RZP-2025-041

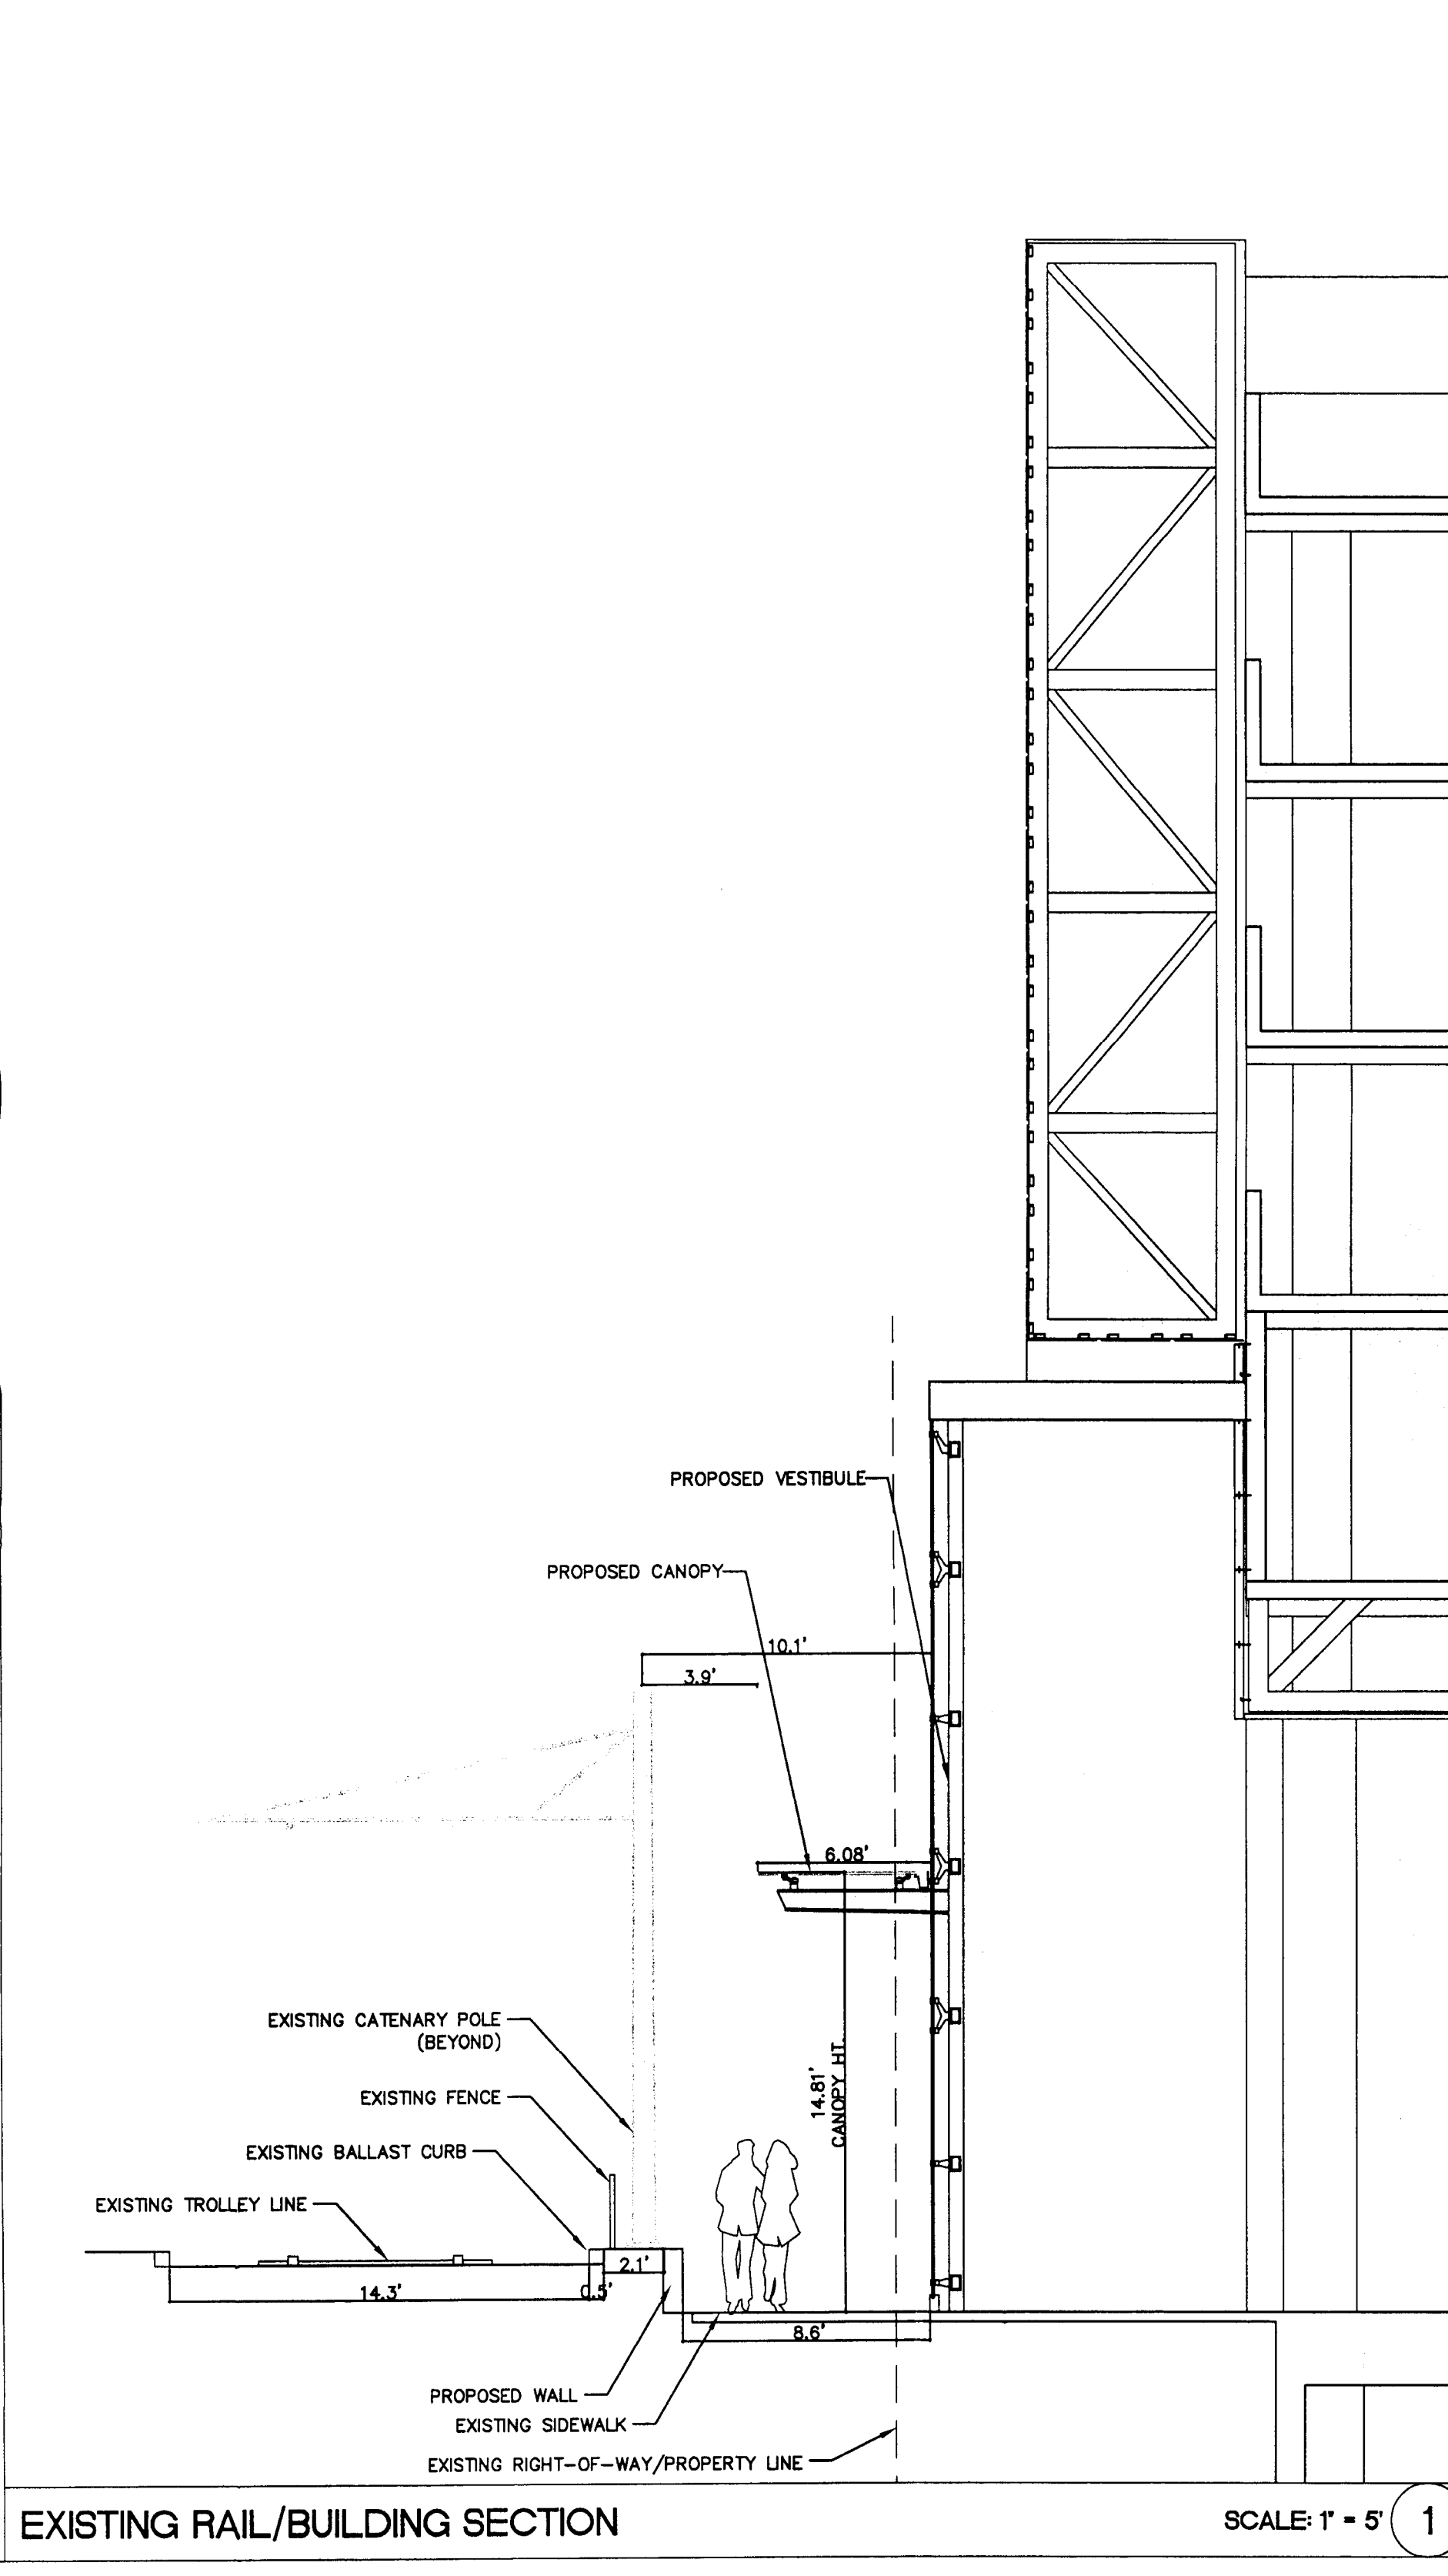
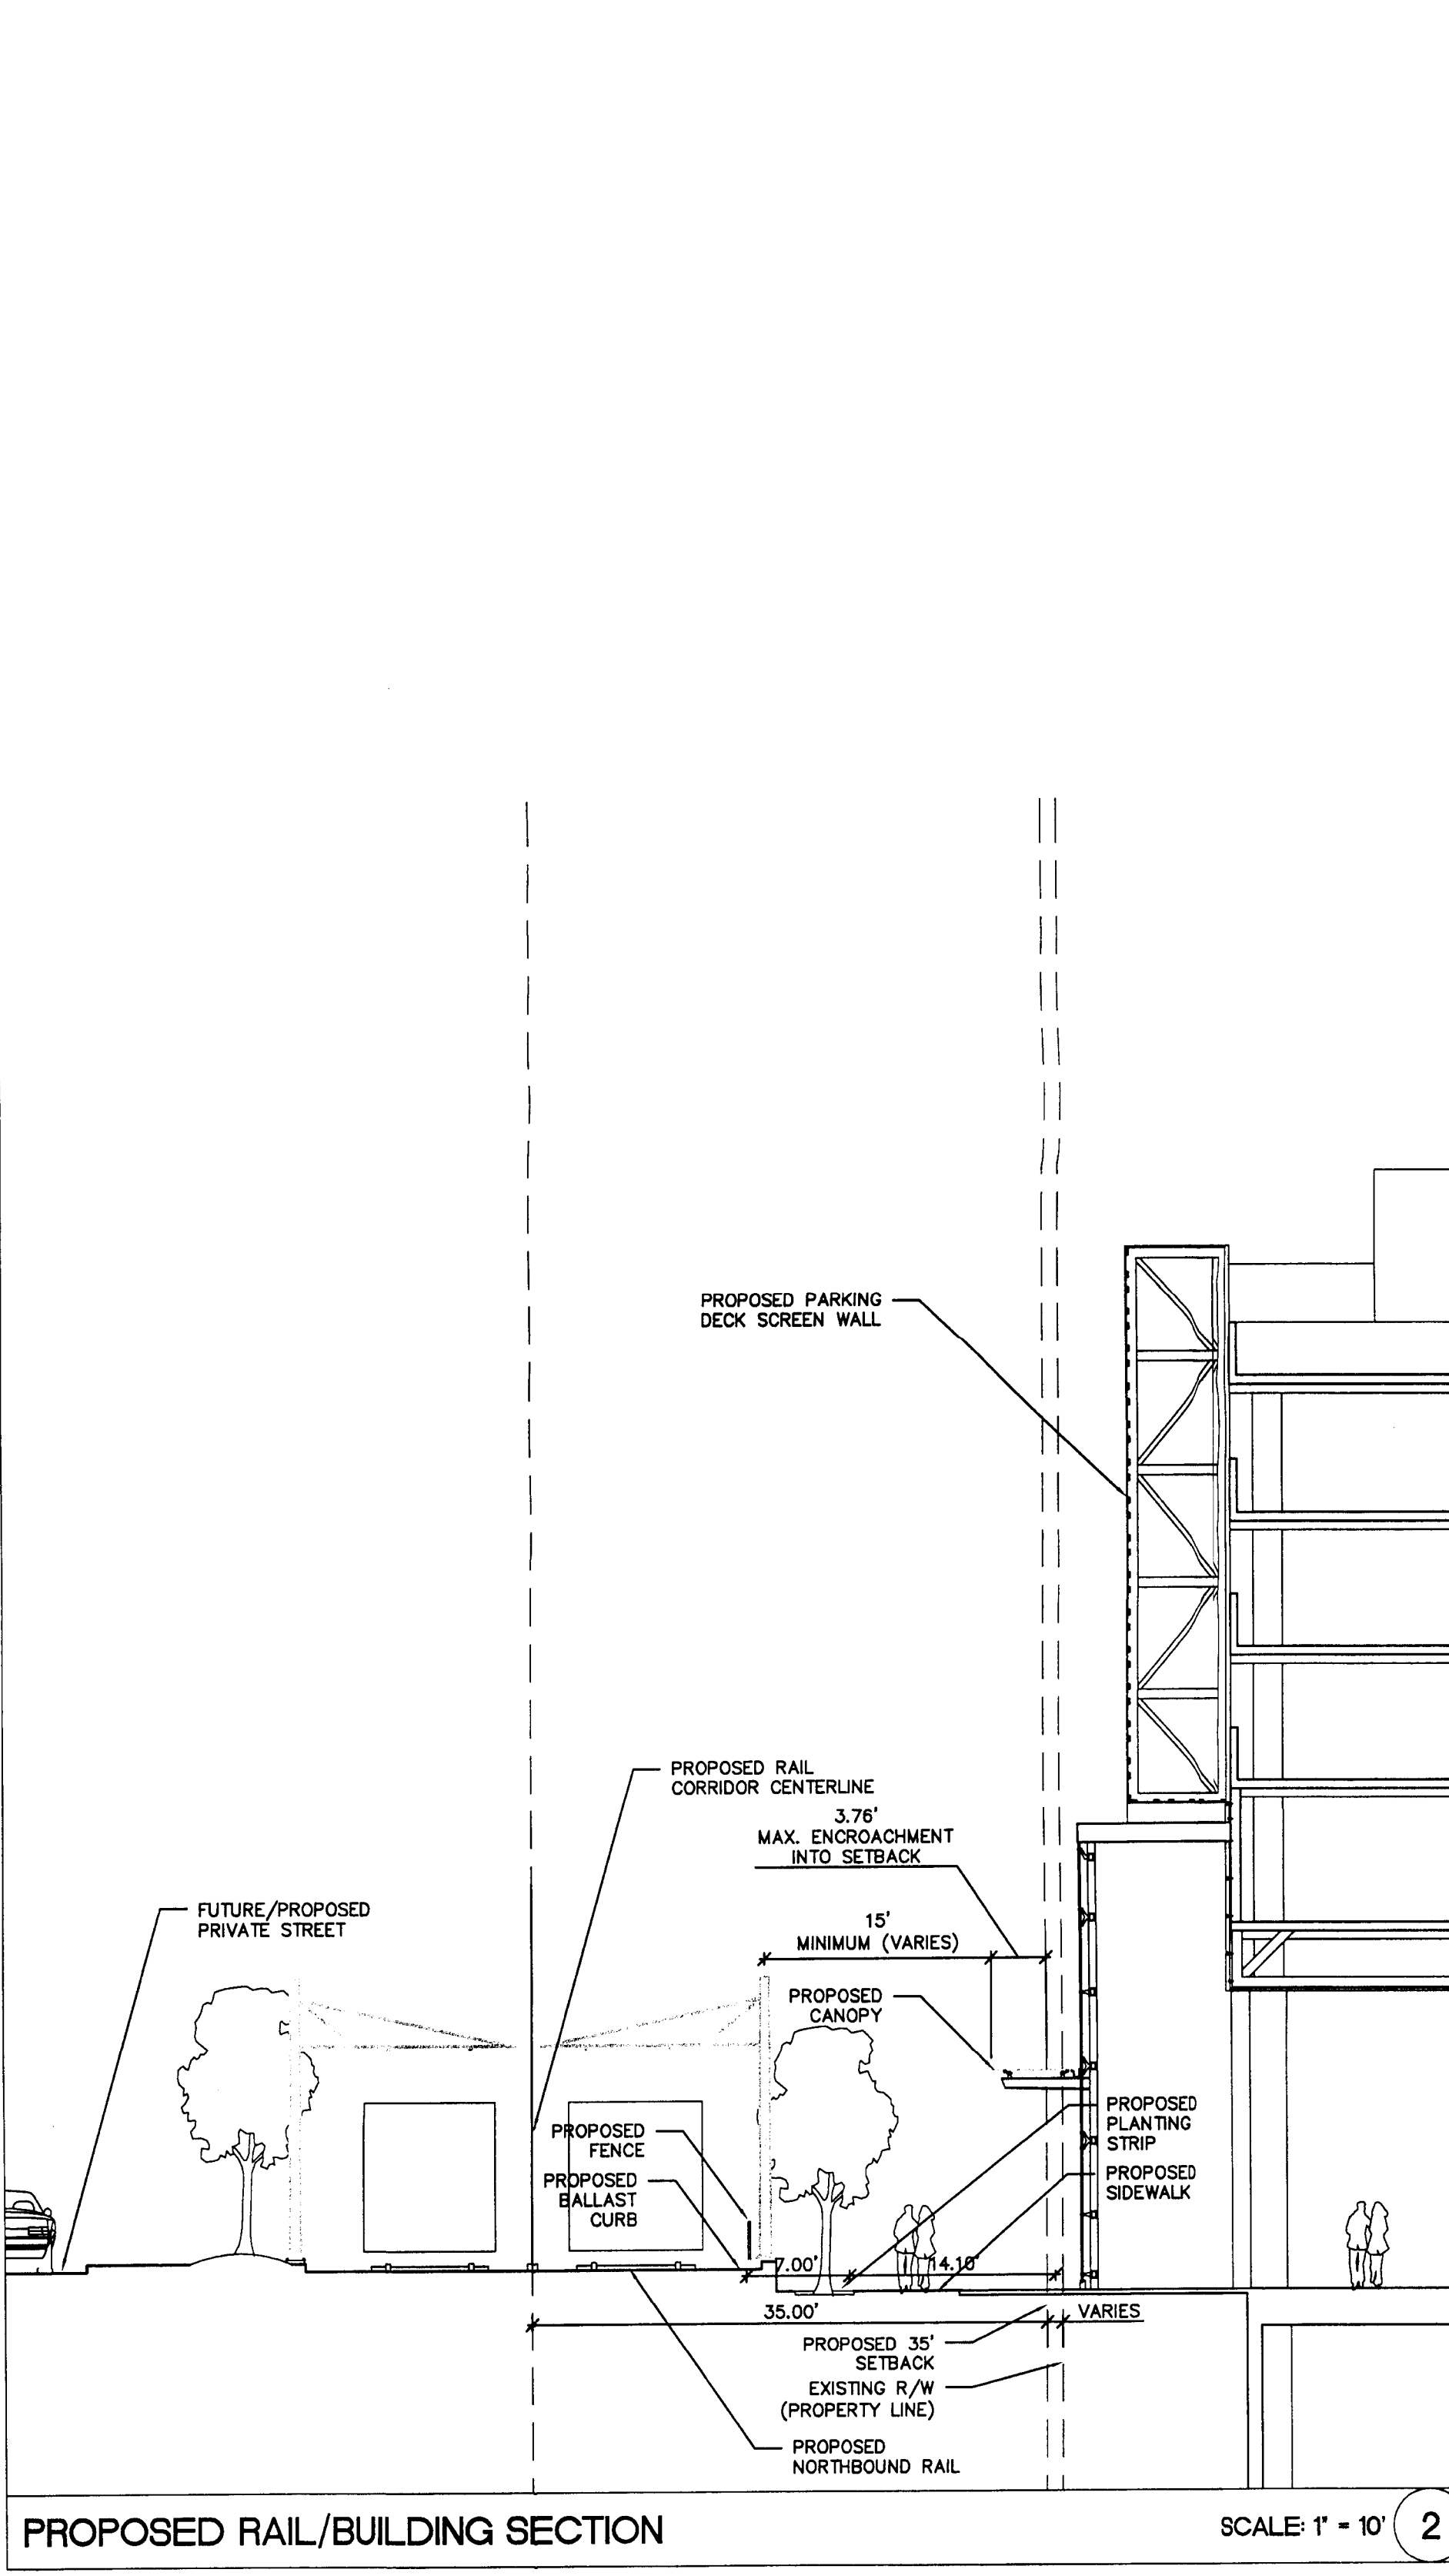
1. ~~Entitlement Services: Add rezoning petition number to site plan.~~ Addressed
-
